Ribble Valley Borough Council
By email

Your ref 3/2025/0141
Our ref DC/25/1918
Date 01-SEP-25

Location: Bolton Fold Farm Alston Lane Longridge PR3 3BN.
Proposal: Regularisation of erection of three commercial buildings (10 commercial units Use Class E)

APPENDIX C

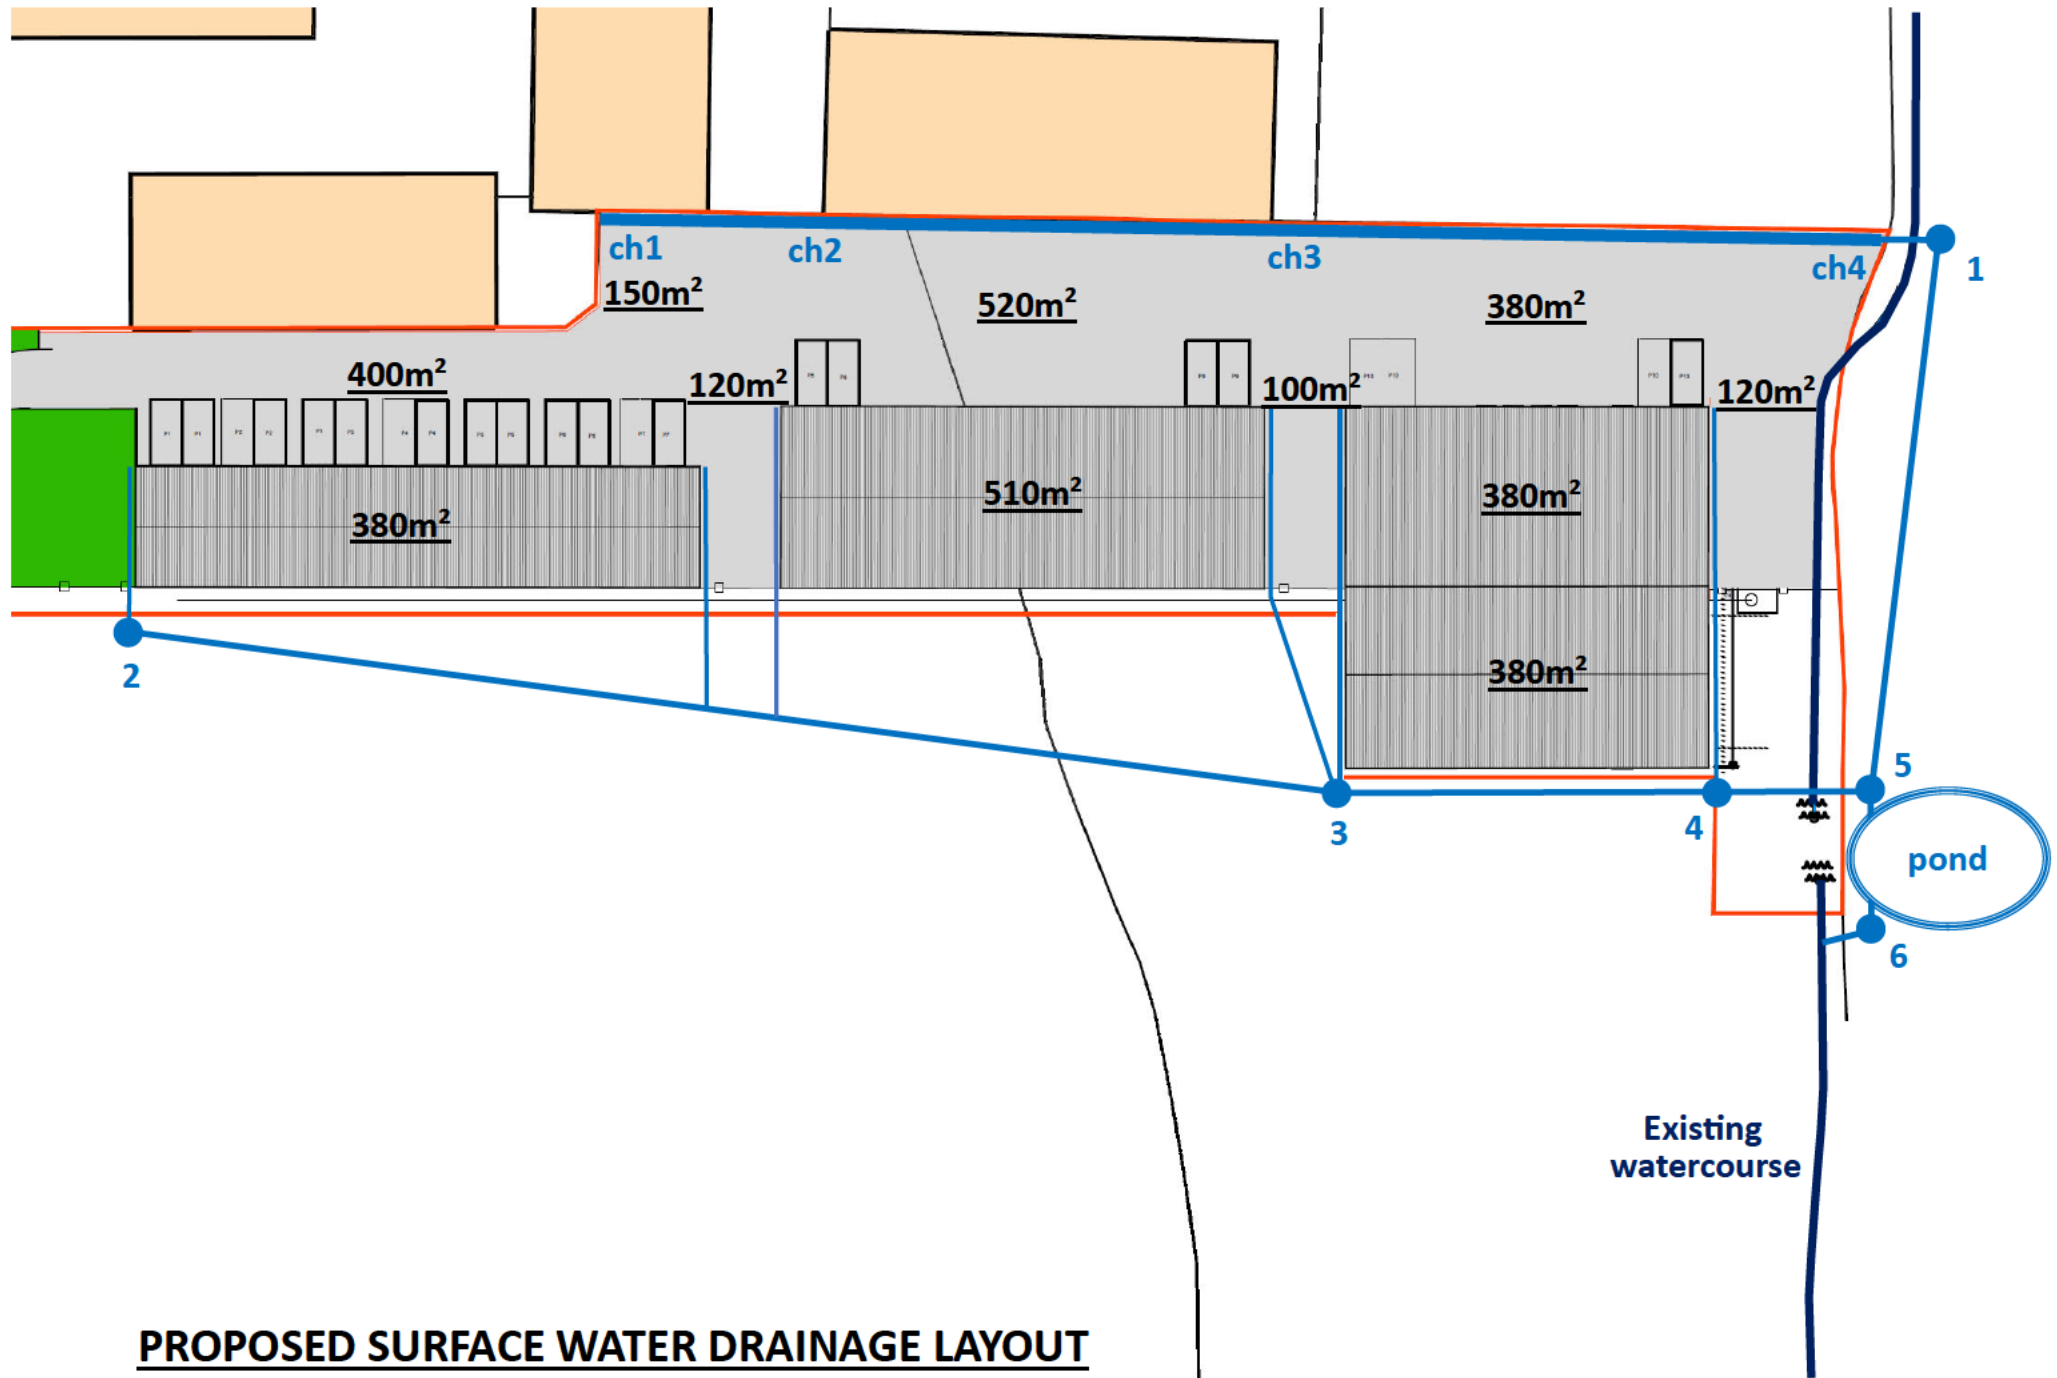
Following our review of the submitted Drainage Strategy Ref: Proposed Surface water drainage layout, we can confirm that whilst the proposals are acceptable in principle, there is insufficient information on the detail of the drainage design. The proposed drawing should show the proposed foul water design and include all indicative levels.

Prior to the commencement of development, details of a sustainable surface water drainage scheme and a foul water drainage scheme shall be submitted to and approved in writing by the Local Planning Authority. The drainage schemes must include:

- (i) An investigation of the hierarchy of drainage options in the National Standards for Sustainable Drainage Systems (or any subsequent amendment thereof). This investigation shall include evidence of an assessment of ground conditions and the potential for infiltration of surface water;***
- (ii) A restricted rate of discharge of surface water agreed with the local planning authority (if it is agreed that infiltration is discounted by the investigations);***
- (iii) Levels of the proposed drainage systems including proposed ground and finished floor levels in AOD;***
- (iv) Incorporate mitigation measures to manage the risk of sewer surcharge where applicable; and***
- (v) Foul and surface water shall drain on separate systems.***
